Frodsham Solar

Environmental Statement: Volume 2

Appendix 9-5: Consultation Responses

May 2025

April 2025

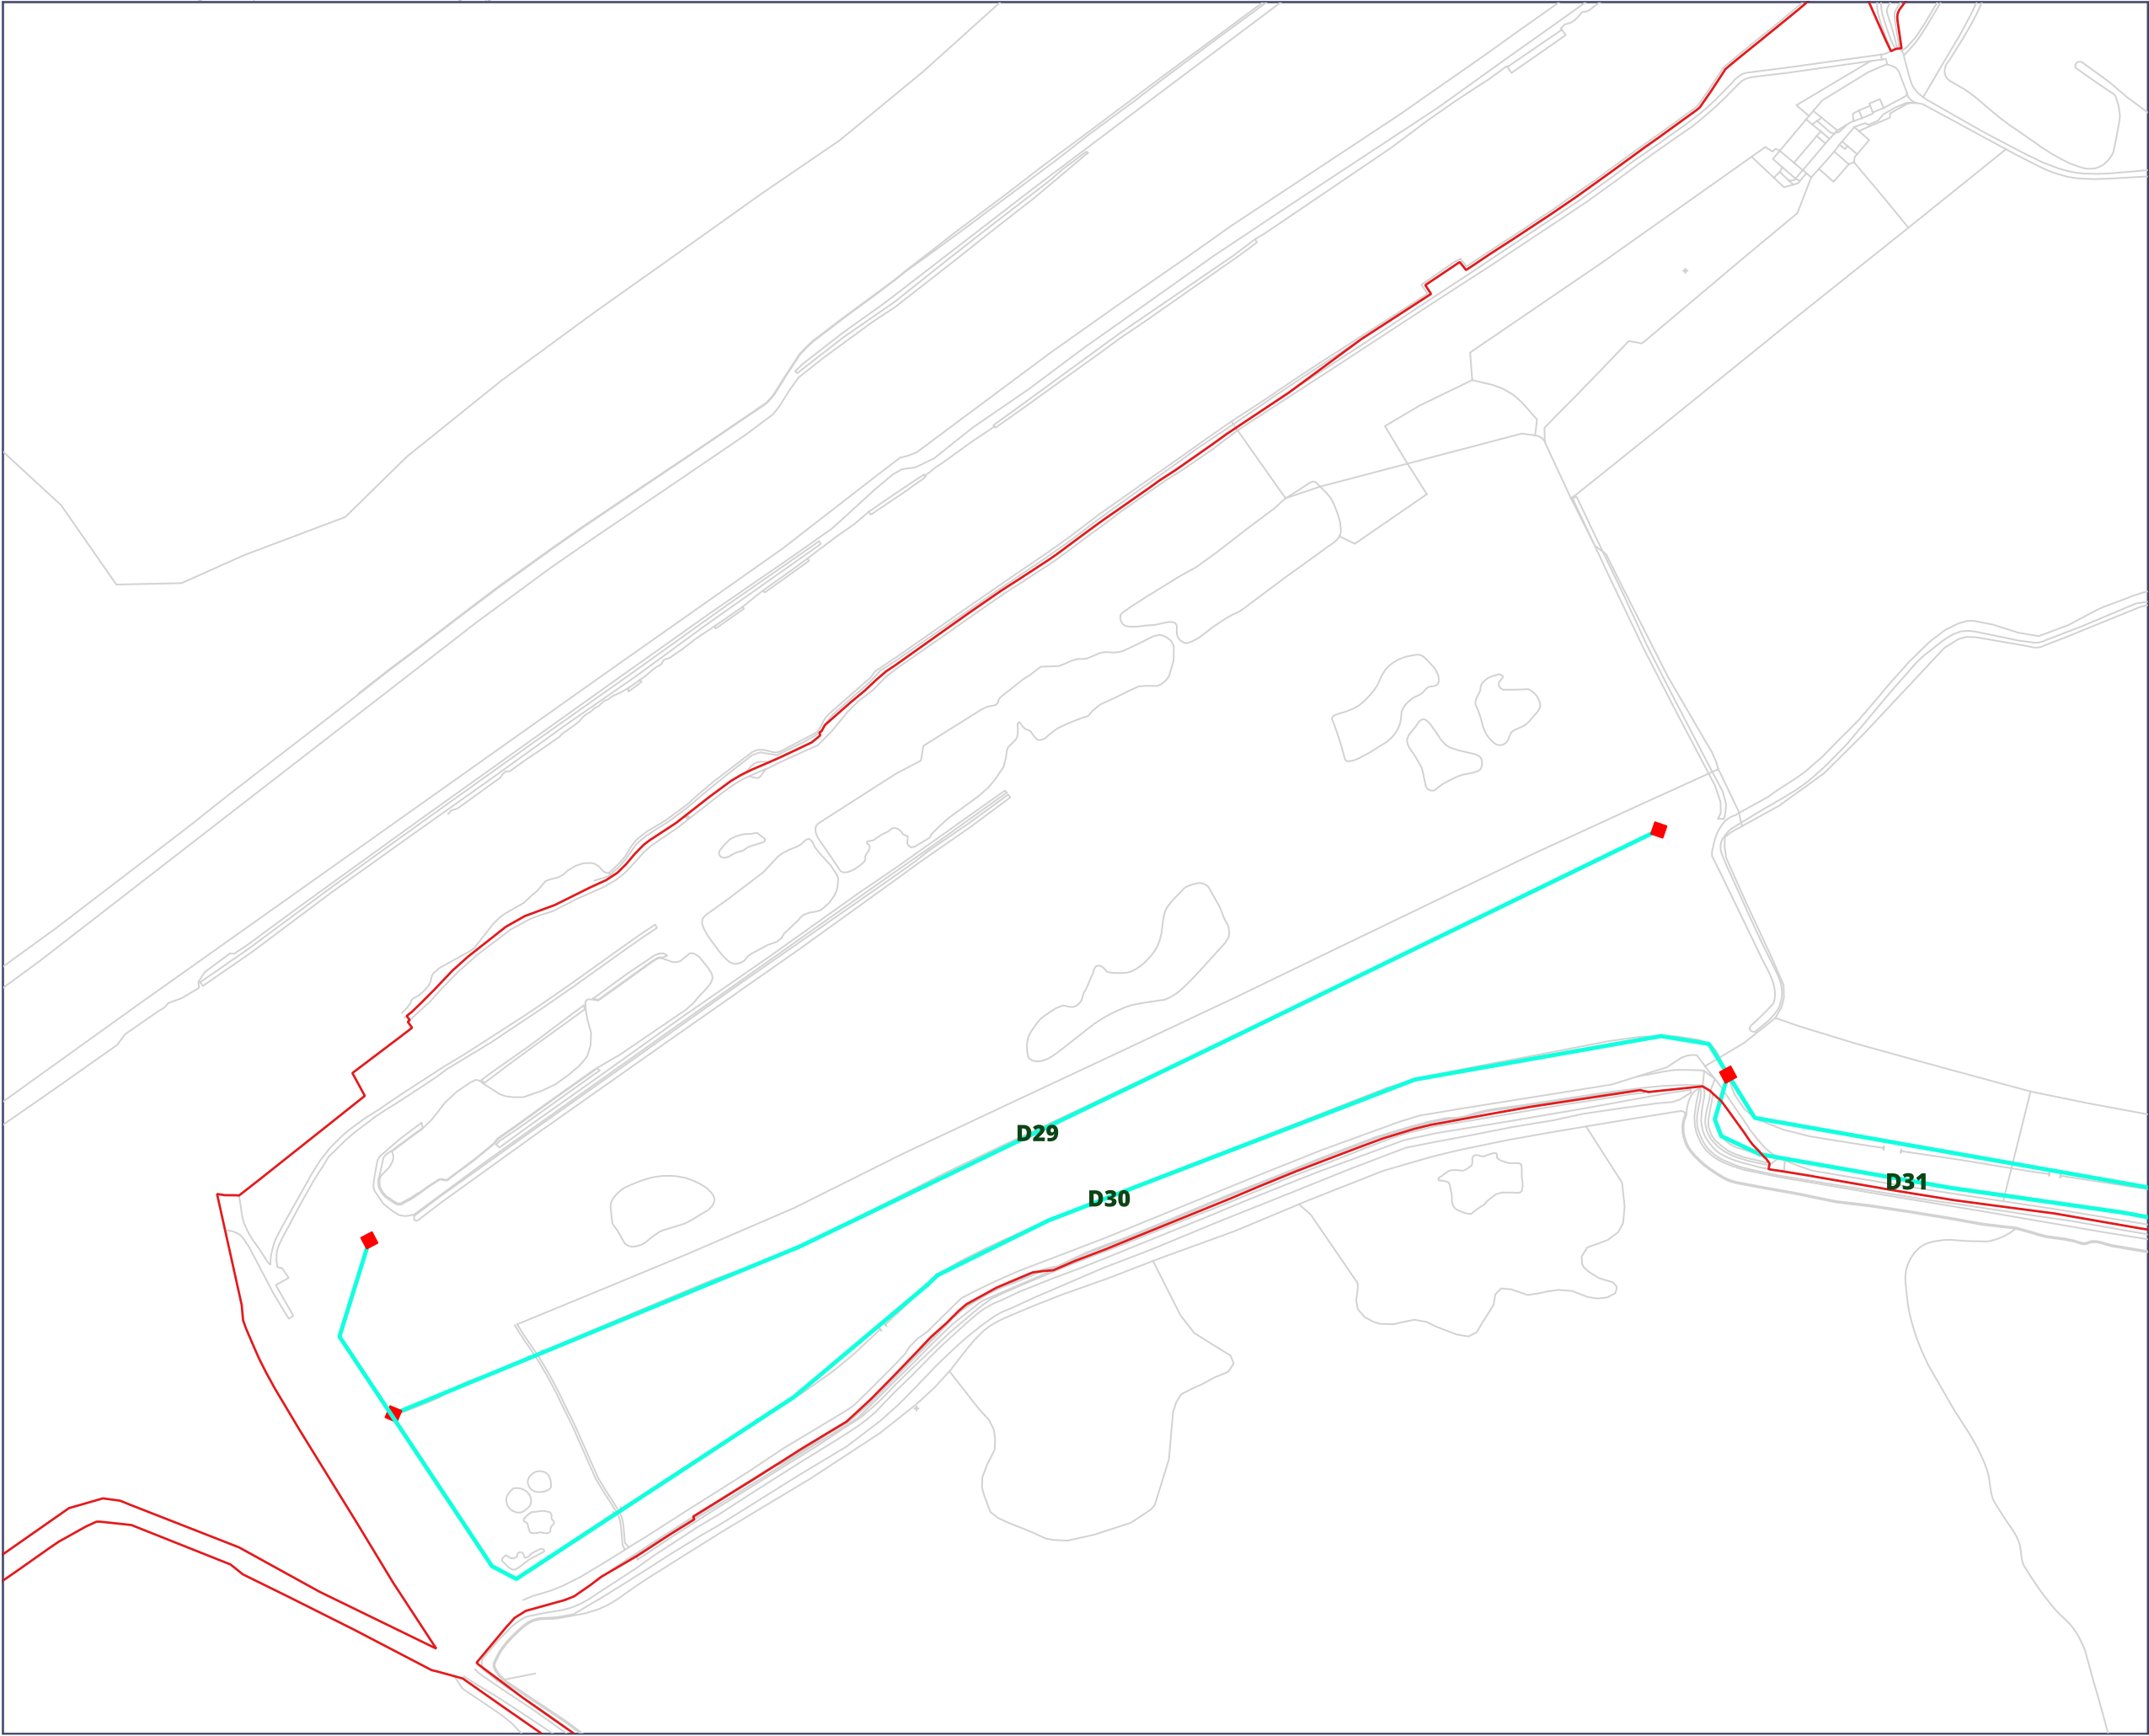
| Respondent | Comment | Has this resulted in a change to the Scheme or the Applicant's evidence? | Applicant response |
|--------------------|--|--|--|
| Environment Agency | Bridge and Cable Crossings of Watercourses (Non-Technical Summary, Paragraphs 2.4.118, 2.5, 3.2.2. Appendix 2-1 Indicative Watercourse Crossing Schedule. Table 2-9: Further associated development within the draft Order Limits in connection with the delivery of Work Nos 1 – 6. Figure 2-5j Indicative Permanent Watercourse Crossing.) Issue We are concerned with details of the proposed crossings, namely the: • the soffit level of the bridges • the potential | Yes | Detailed technical consideration of all crossing points has been made with full details provided in the ES Volume 2 Appendix 9-1: Flood Risk Assessment and Drainage Strategy [EN010153/DR/6.2]. No culverts proposed. All new or replacement access crossings over EA designated Main Rivers will comprise open span bridge structures with a soffit level set 600mm above the |

| Respondent | Comment | Has this resulted in a change to the Scheme or the Applicant's evidence? | Applicant response |
|--------------------|---|--|--|
| | <p>extension of existing culverts Impact The bridges may restrict future maintenance of the watercourse and works to flood assets. Culverts can lead to an increase in flood risk, have a risk of blockage, and pose a maintenance burden.</p> <p>Solution Alternative cable crossing options should be considered. The soffit levels of bridges should be raised 600mm above the design flood level. We recognise this may have knock on effects to the proposed development, and would encourage the developer to liaise with us further on this issue. Instead of installing / extending (existing) culverts, the applicant should consider installing a clear-span bridge crossing. Given that there are circa 25 crossings as part of this proposal, the applicant will need to model changes in flood risk from the proposed crossings.</p> <p>Our position on this is supported by paragraphs 2.10.87 and 2.10.88 of National Policy Statement EN-3, which state that: • culverting existing watercourses should be avoided • where culverting for access is unavoidable, applicants should demonstrate that no reasonable alternatives exist, and where necessary it will only be in place temporarily for the construction period.</p> | | <p>1% annual probability plus 67% climate change in-channel water level of the relevant watercourse.</p> <p>All new or replacement access crossings over designated 'Ordinary Watercourses' will comprise open span bridge structures with a soffit level set above the top bank level of the watercourse.</p> <p>The watercourse crossings will not reduce the channel capacity and as such will not impact on flood risk on site or elsewhere.</p> <p>Please see the Bridge Design Technical Note appended to the ES Volume 2 Appendix 9-1: Flood Risk Assessment and Drainage Strategy [EN010153/DR/6.2].</p> |
